Pagham Beach (Holdings) Ltd

7th December 2021

re. ADC Application ref: P/157/21/PL

Proposal: demolition of existing sub-standard dwelling and erection of new dwelling

DRAWING TITLE: Elevations

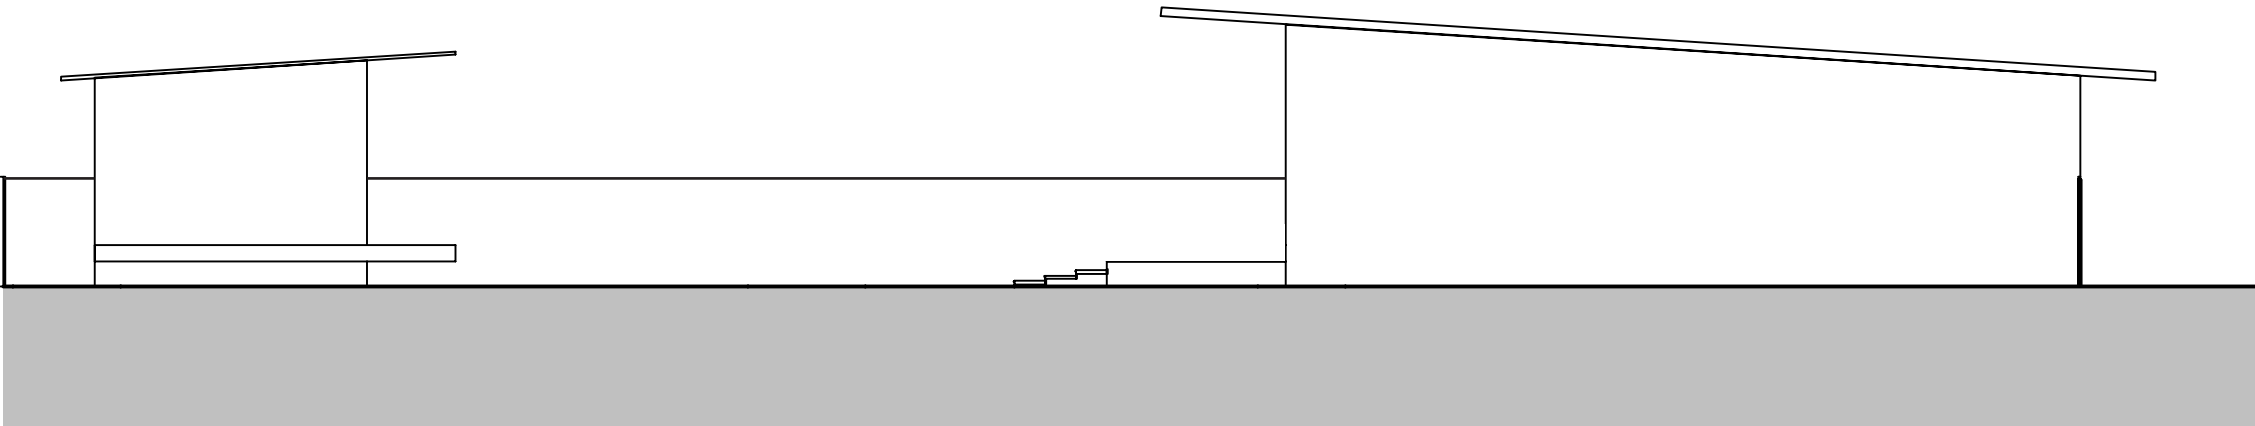
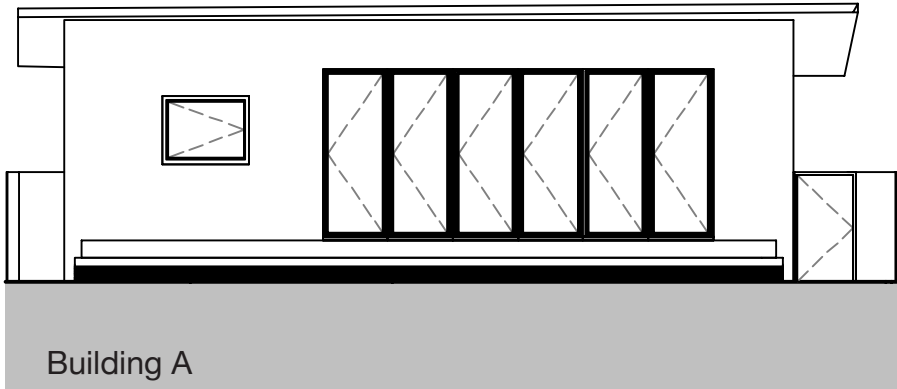
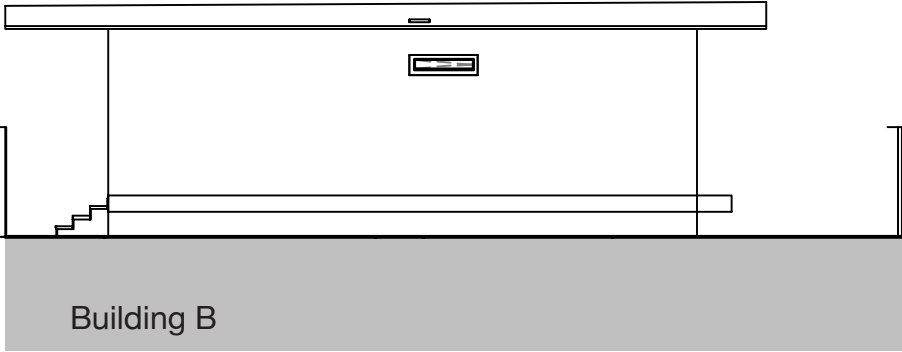
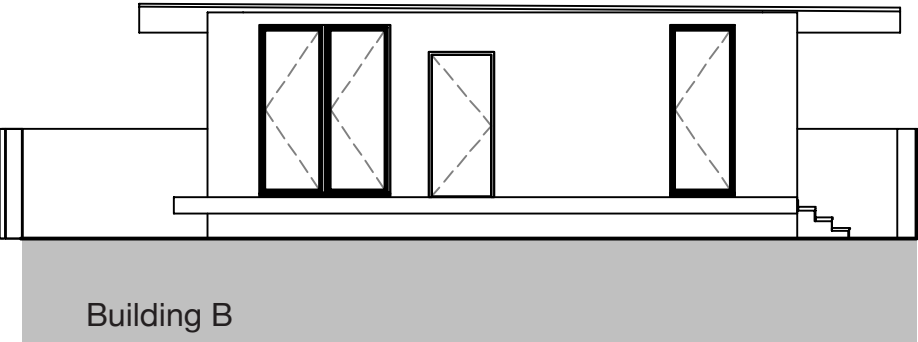
- The Design & Access Statement under Size, Scale & Visual Impact, states that the front entrance door is accessed through a small courtyard. The enclosure of this courtyard is not shown on the Elevation Drawing and details should be provided in order that the impact on the street scene can be considered. Please also define the height and construction of the screens enclosing this courtyard.

02. Roof Plan

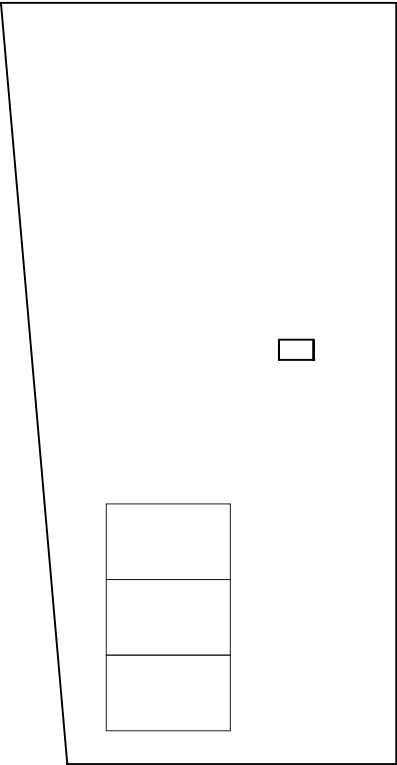
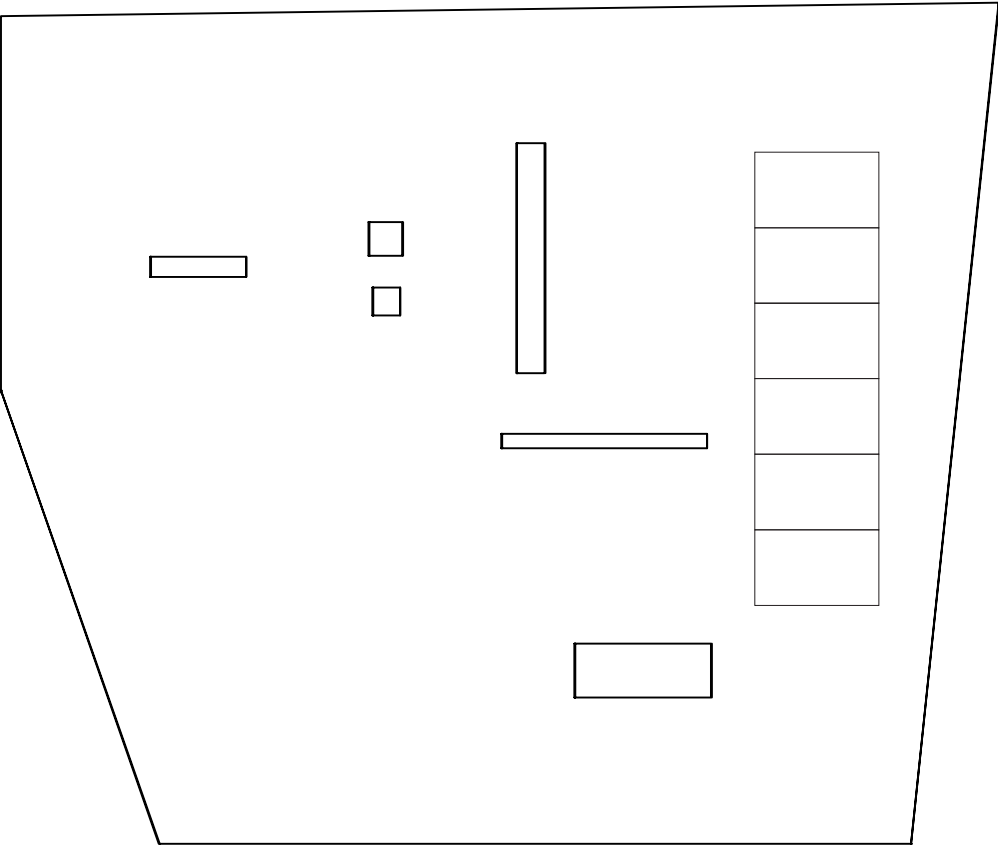
- The roof plans show rectangles within the mono-pitch roof slope; please clarify which rectangles represent rooflights and which represent photovoltaic or other solar panels. Also show position of rooflights superimposed over the Ground Floor Plan in the usual manner.
